Application for Removal or Variation of a Condition following Grant of Planning Permission or Listed Building Consent

Erection of a single storey and 2 storey extensions, removal of internal wall, conversion of garage and installation of replacement windows, external doors and rainwater goods and external landscaping

21/0941/LBC

Response to planning for Simon Forshaw

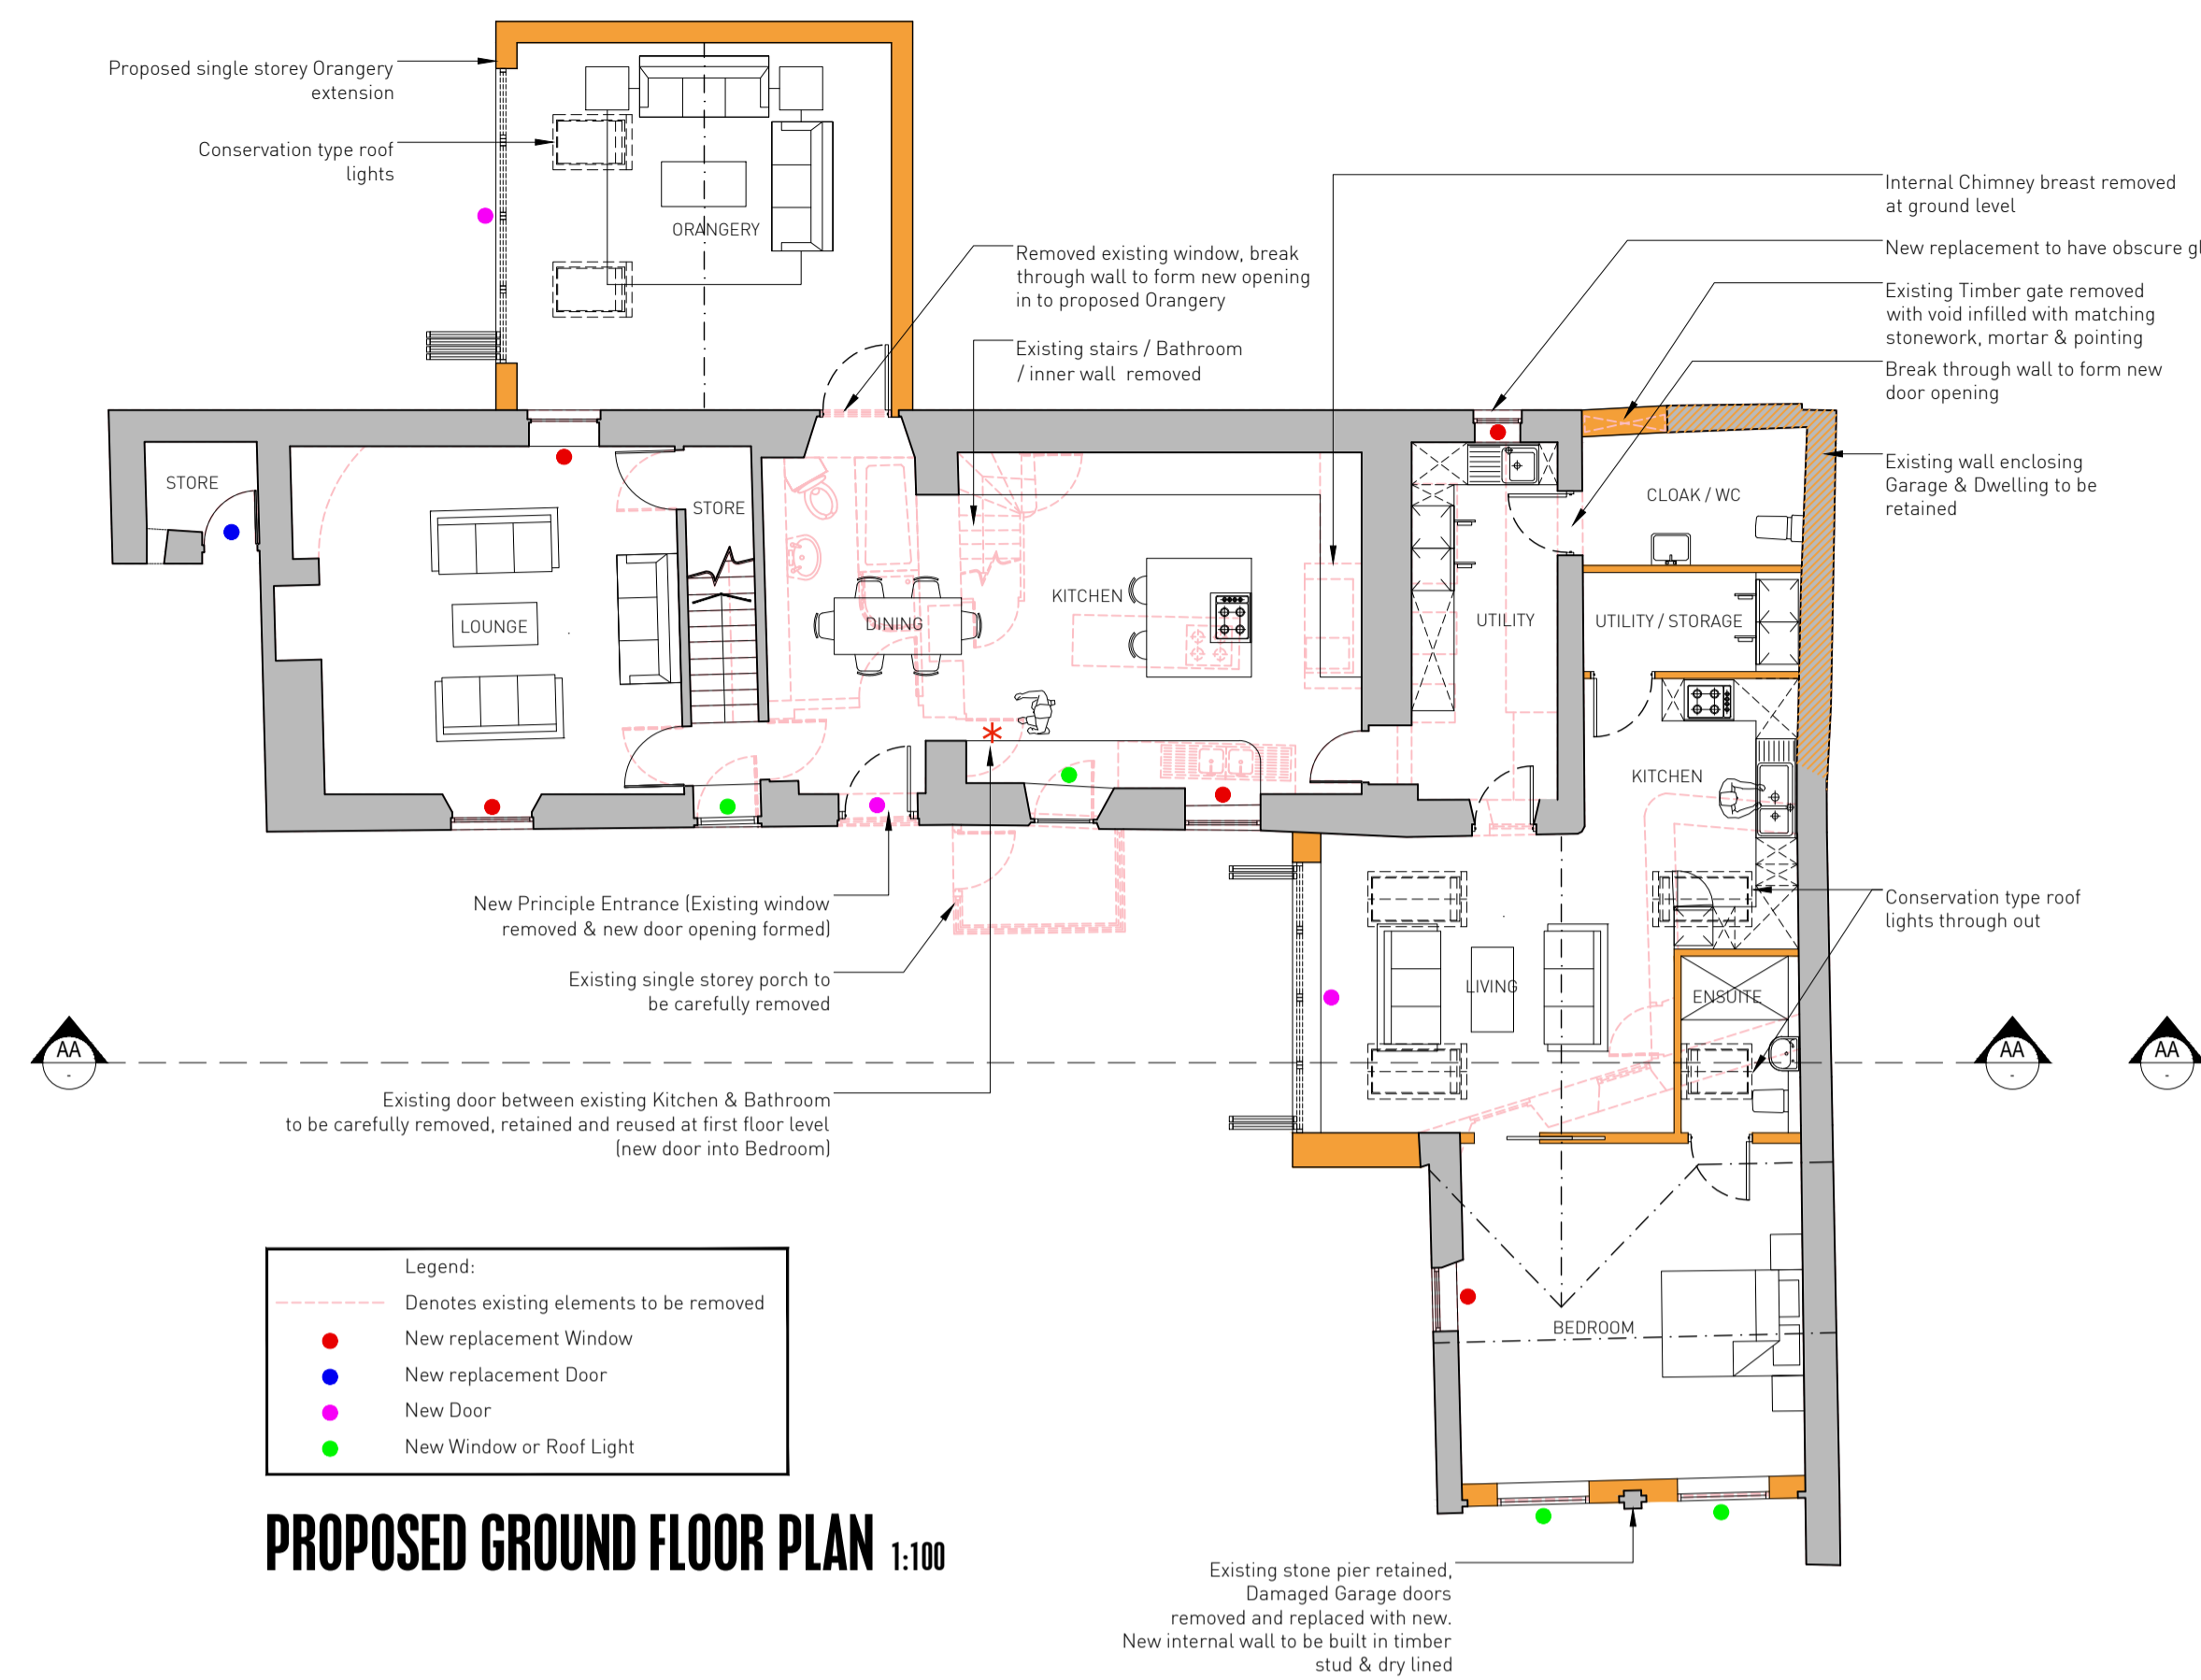
A 1st floor window on rear elevation, not shown on the approved plans, has been installed. Window in question is indicated on the approved drawings.

The faux garage doors have not been installed; instead, the apertures have been partially infilled with the intention of windows being installed in their place contrary to the approved plans. Refer to amended drawings.

The external windows and roof lights of the orangery are not in accordance with the approved plans. Drawings show 5 windows and 5 connected roof lights above. The development was found to have 4 windows and 2 separate conservation type roof lights. Refer to amended drawings.

The roof line of the garage and front connecting single storey extension are not in accordance with the approved plans. From inspecting the plans and consulting a resident joiner, it is clear that due to the different roof pitches the valleys will not marry up and the plans cannot be built out correctly. This statement is supported by what has been seen as built on site. Refer to amended drawings.
